**Defence
Infrastructure
Organisation**

Your reference: TR02002

Application by River Oak Strategic Partners for an Order granting Development Consent

I am writing in response to the Examining Authority's Fourth Written questions and to provide comments on the dDCO. However, before responding to the specific points raised by these questions and providing comments on the dDCO, I consider it would be helpful to summarise the position in regard to the various matters relating to the MoD, as follows:-

4.05 Uses - Cargo Area

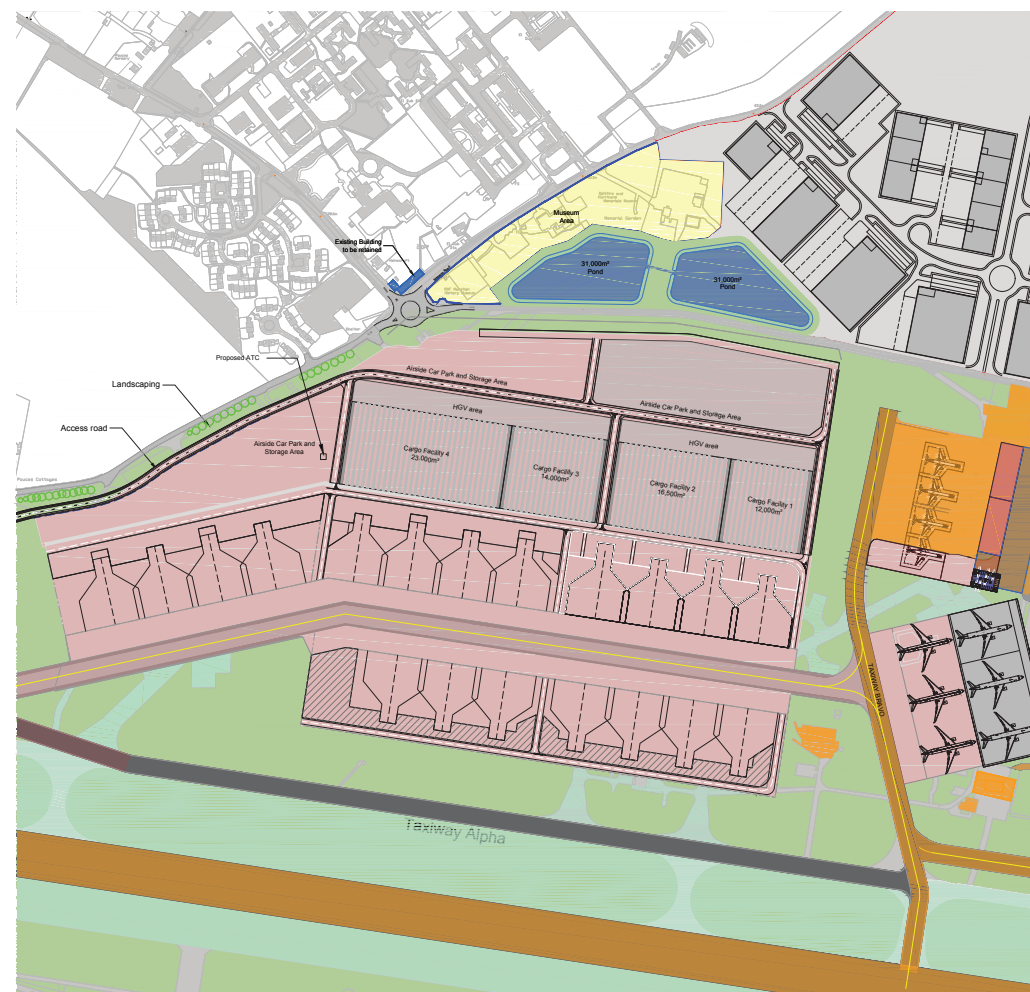
Therefore, until testing has been carried out and deemed successful by the MOD and its stakeholders, construction will be delayed. The MOD cannot accept any degradation to the HRDF facility. The application in its current design regarding the ATC towers, Cargo buildings and aircraft parking bays infringe the statutory technical safeguarding zone surrounding the Manston HRDF. We would need to ensure that development will not impact on the HRDF.

Cargo Buildings – approximately 25m above ground level; 410m distance from HRDF

Aircraft parking – commercial jet aircraft within 100m to HRDF

Air Traffic Control Tower- 24m above ground level 460m distance from the HRDF

The design plan for the proposed application is not compatible with the current HRDF location. The problem is the scale, mass and proximity to the HRDF.

Therefore, development immediately north and west of the HRDF is of concern to the MOD and the reason behind our objection response. The MOD originally submitted our objection to the applicant in 2017 stating their
